Your Ref: A/169/17/OUT

Our Ref: NW/ARU/17/15/B

Date: 17<sup>th</sup> October.2017

### **RE.Land West of Brook Lane and South of A259 Angmering**

MASTER PLAN

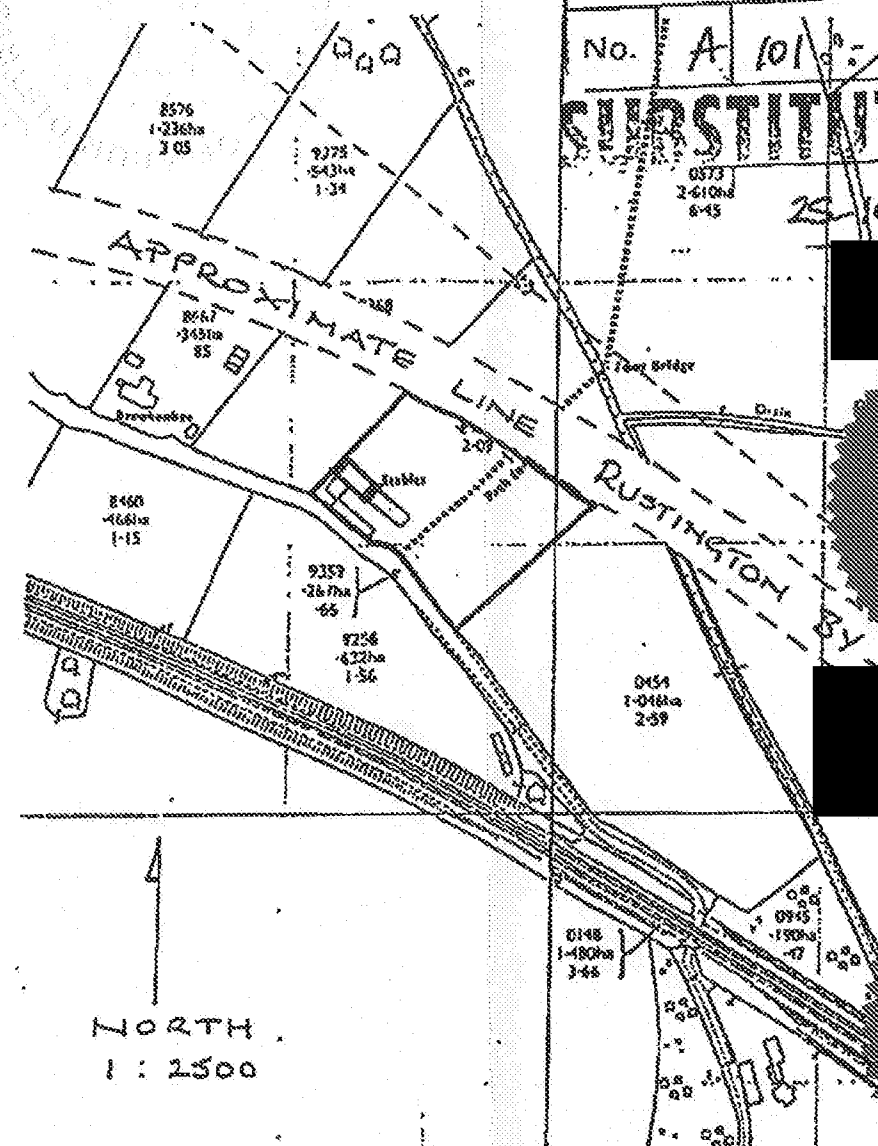
In addition to those comments I note that there are proposals to install 900mm high lighting bollards at many locations across the site together with a limited number of WSCC approved lamp posts. Bollard lighting is not compliant with Secure by Design 'Homes 2016' recommended lighting advice of BS5489:2013 as it does not project sufficient light at the right height and distorts available light due to its up lighting effect, making it difficult to recognise facial features and as a result causes an increase in the fear of crime.

I have concerns that the new public footpath link at the west end of the development across the proposed public space is out of sight of nearby housing which may attract crime and antisocial behaviour. Illuminating locations isolated from view can be very beneficial but sometimes attract unwanted behaviour and the low bollard lighting may be subject to damage.

The proposed footbridge over the railway will act as a pinch point for walkers accessing the development. I am pleased to see that during the hours of darkness the bridge will be illuminated by Network Rail. The lighting should also be vandal resistant.

Any parking areas surrounding the communal flats and apartments where a number of vehicles may be parked should be illuminated and in view of active rooms. An active room is where there is direct and visual connection between the room and the street or the car parking area. Such visual connections can be expected from rooms such as kitchens and living rooms, but not from bedrooms and bathrooms. Gable ended windows can assist in providing observation over an otherwise unobserved area.

Although I have viewed the descriptive letter from St Matthews ( its potential user ) regarding facilities and management it could provide I am unable to find any plans for the 'Care Home' proposed for the eastern end of the development and therefore cannot make any recommendations.
